WEST SUSSEX COUNTY COUNCIL CONSULTATION

TO:	Arun District Council FAO: Zac Denton
FROM:	Highways, WSCC
DATE:	16/01/2019
LOCATION:	21 Beaumont Park, Littlehampton, BN17 6PE
SUBJECT:	LU/257/18/HH Installation of crossover and hardstanding
DATE OF SITE VISIT:	N/A
RECOMMENDATION:	☒ Advice ☐ Objection ☐ Modification ☐ No Objection ☐ More Information ☐ Refusal
S106 CONTRIBUTION TOTAL:	£N/A

Drawing Title:
Existing and Proposed Site Plans

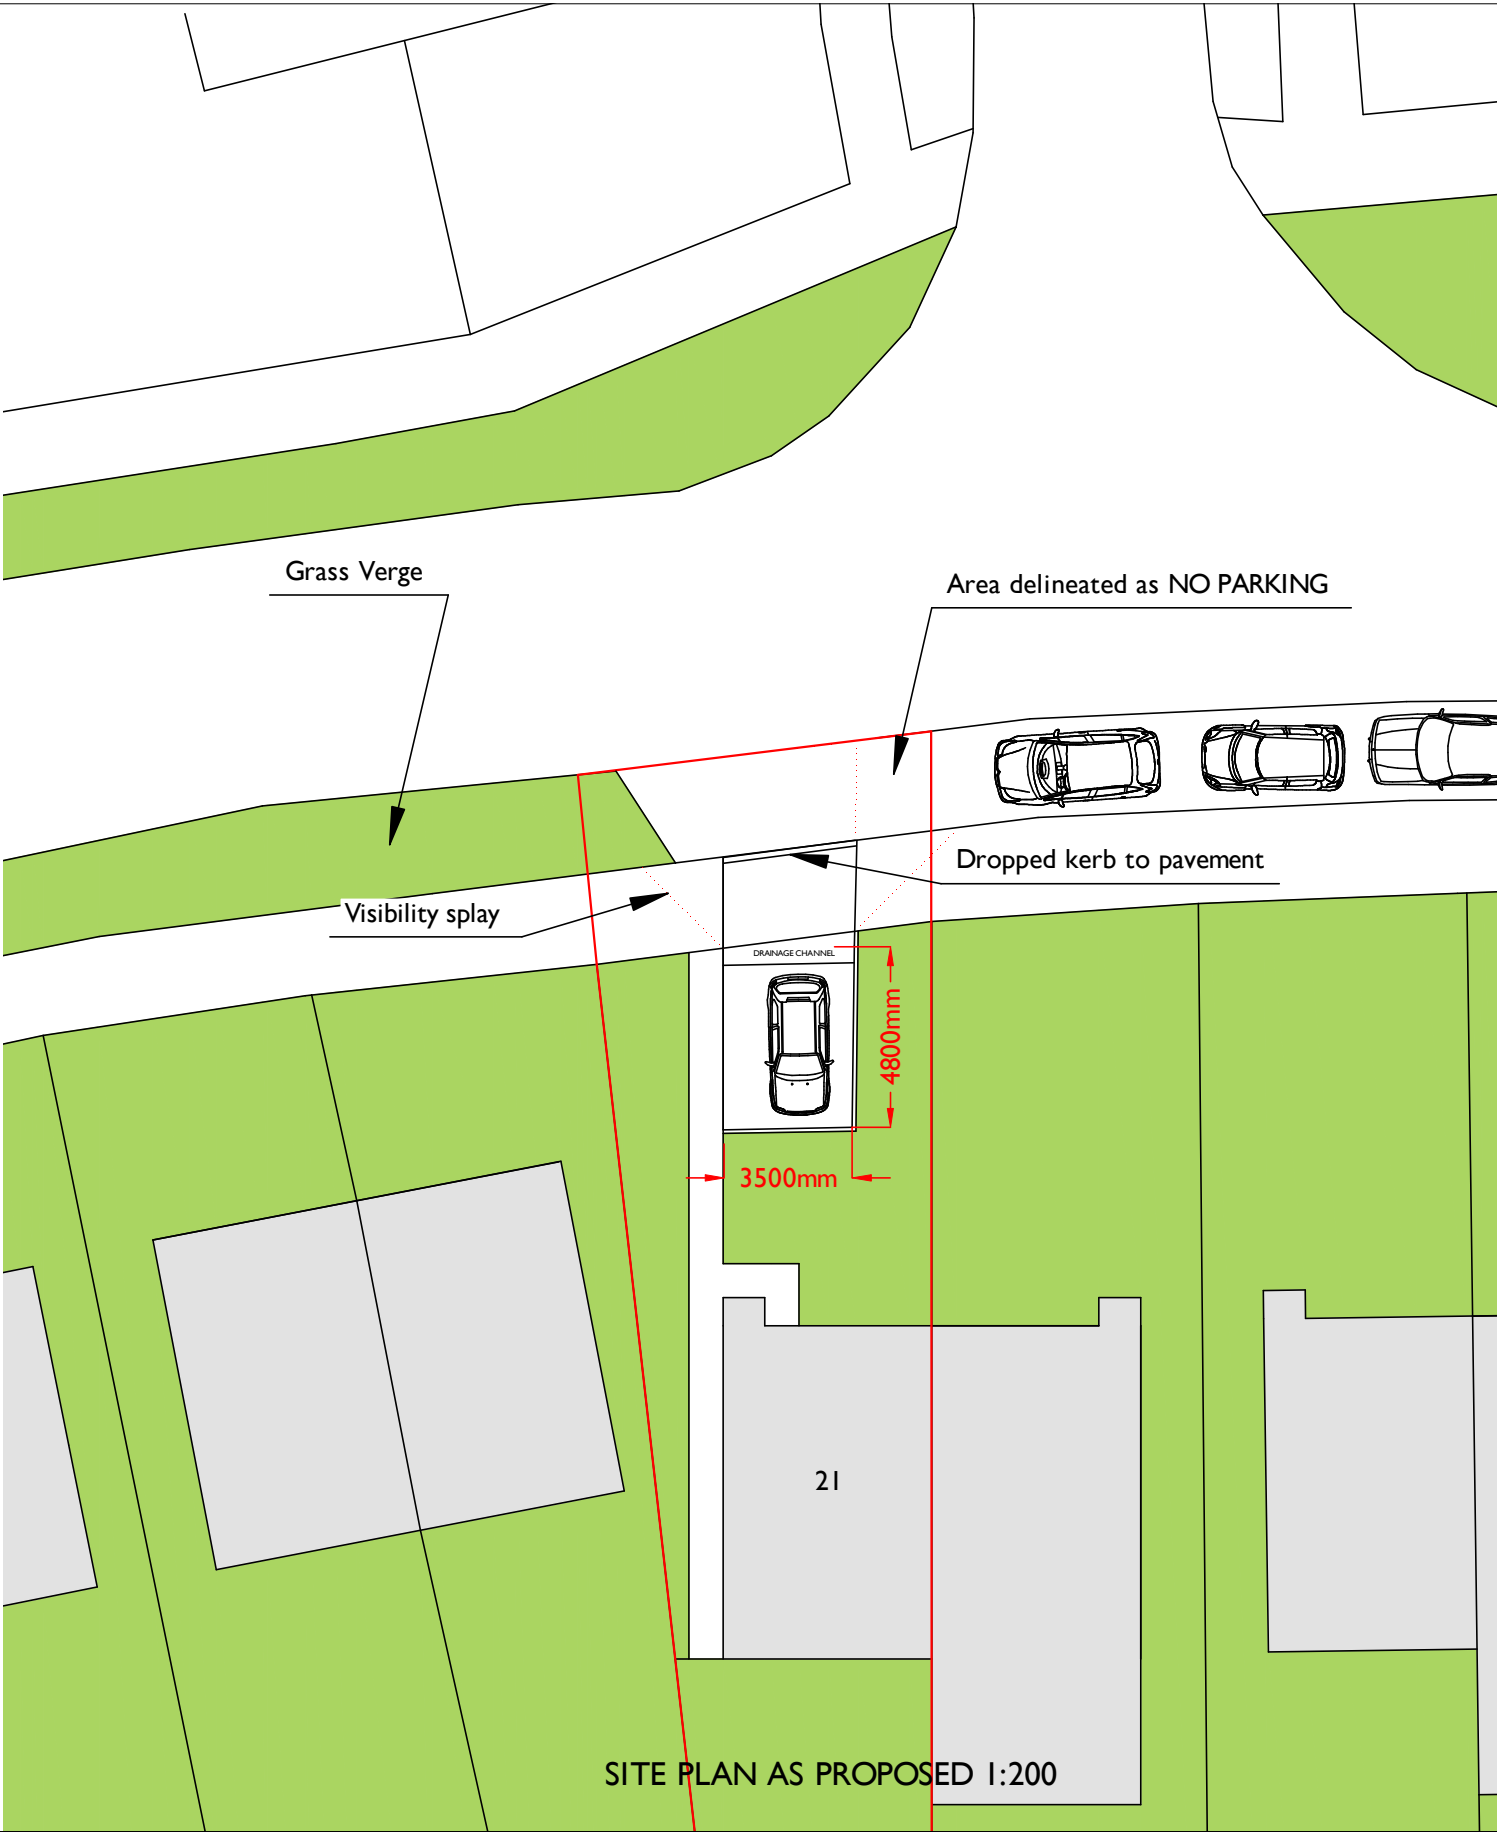
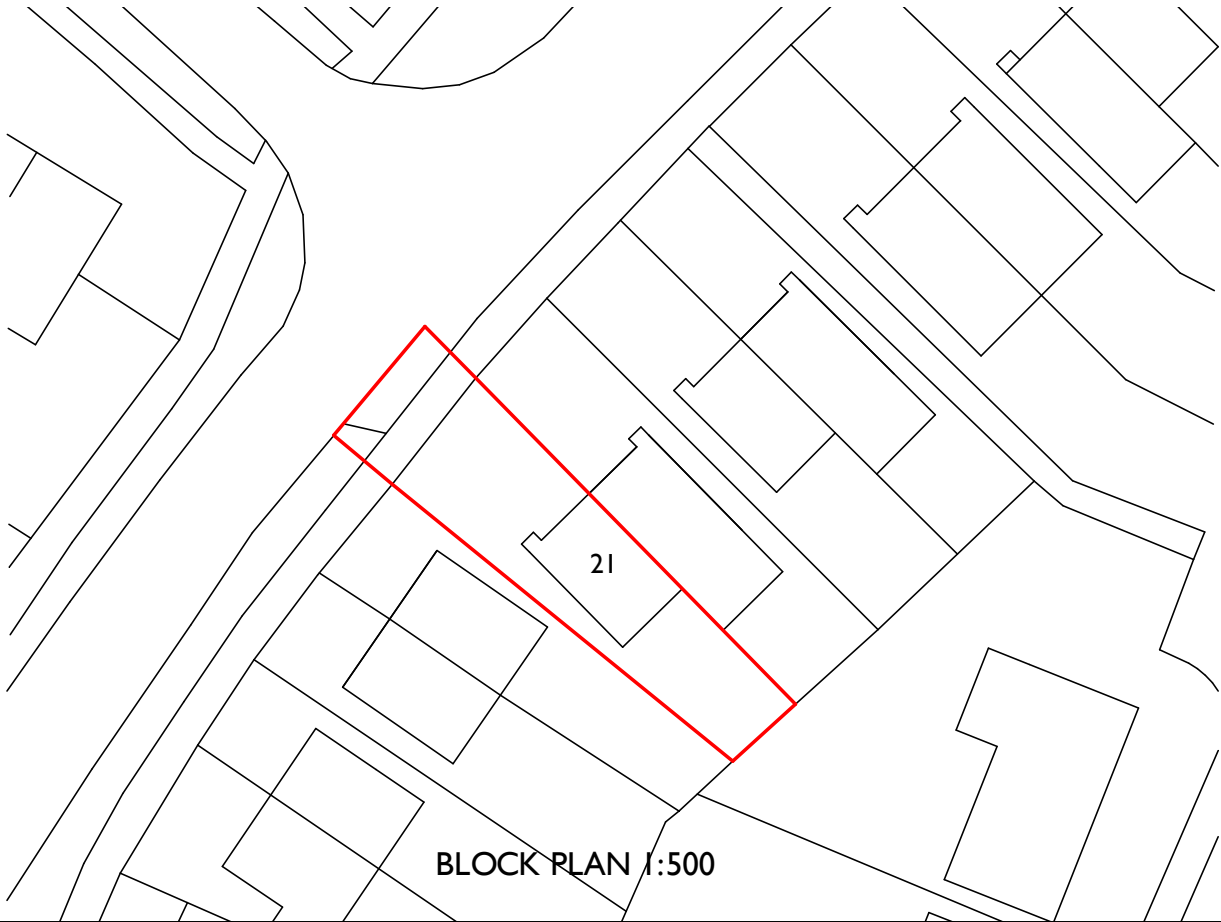
The provided plans and local mapping indicate that the site does not currently benefit from a VCO. A licence will be required for the proposed VCO works onto Beaumont Park. The applicant should be aware that the Local Area Engineer is unlikely to grant a licence for a VCO in this location as it crosses through a layby and would result in the loss of on-street parking.

Accurate visibility splays demonstrating a minimum stopping sight distance of 43m at a distance of 2.4m back from the carriageway edge for a 30mph road have not been provided. However, an inspection of WSCC mapping indicates that these splays are achievable at this location and are maintainable wholly within the Highway.

The proposed plans demonstrate that a single parking space will be provided on site, constructed from a hardbound material preventing spillage of material onto the Highway. A turn on site would be preferred however; there is insufficient space on site to accommodate this.

The use of the access shall not commence until such time as the parking area has been constructed in accordance with the details shown on the drawing titled Existing and Proposed Site Plan Rev A.

The use of the parking area shall not commence until such time as the vehicular access serving the dwelling has been constructed in accordance with the details has been provided shown on the drawing titled Existing and Proposed Site Plan Rev A. These spaces shall thereafter be retained at all times for their designated purpose.
